From: Anita Gardner
Sent: 12 February 2015 15:36
To: [REDACTED]
Subject: FG/20/15/DOC - Balcony screening 9 Marine Drive, Ferring

1008 SK14A
West Elevation
Ferring Marine
Scale 1:50

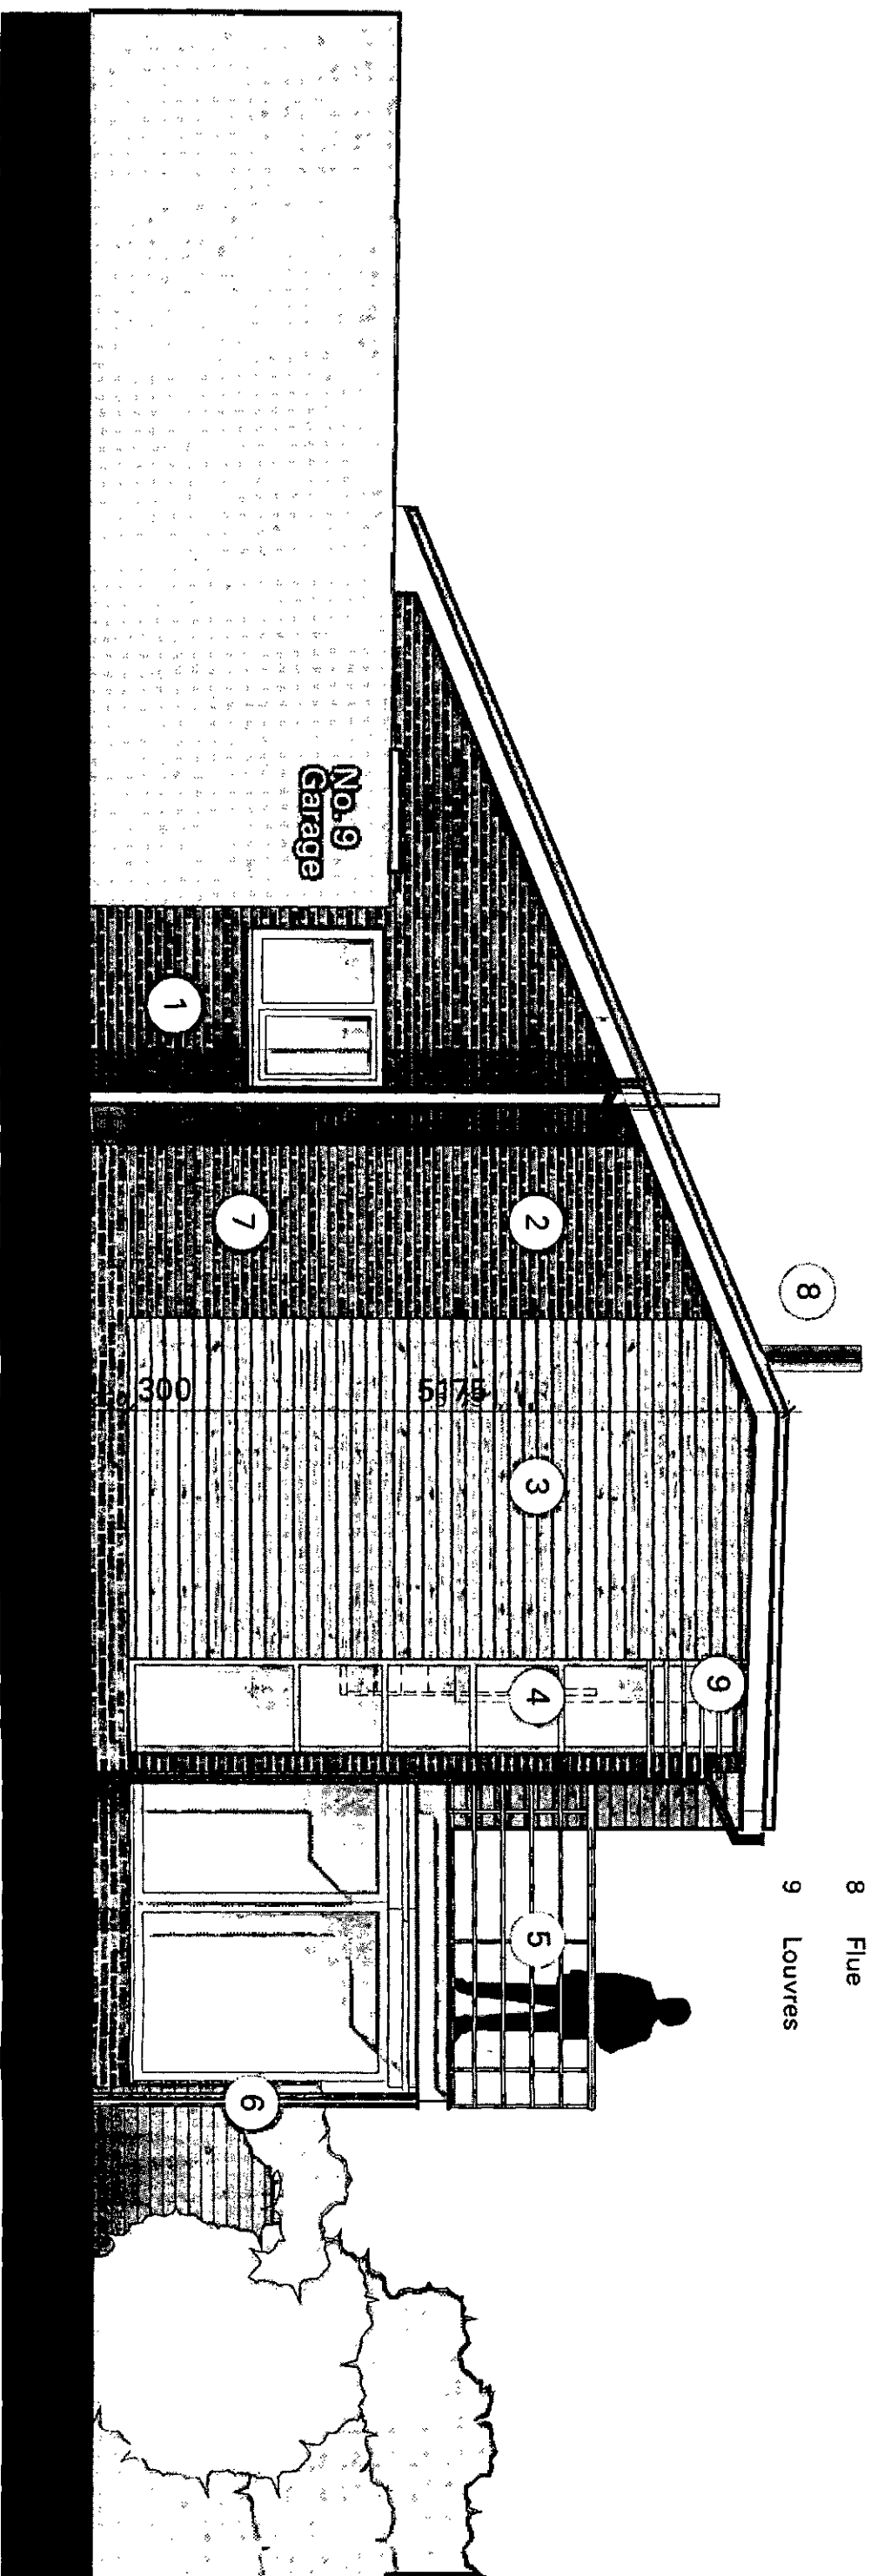
I refer to the above application. The details submitted are not acceptable. The balcony ends would need to be screened with 'obscure' glazing, not opaque and the screening would need to extend the depth of the balcony at a height of 1.8m as stated in the condition, not just a 0.3m depth.
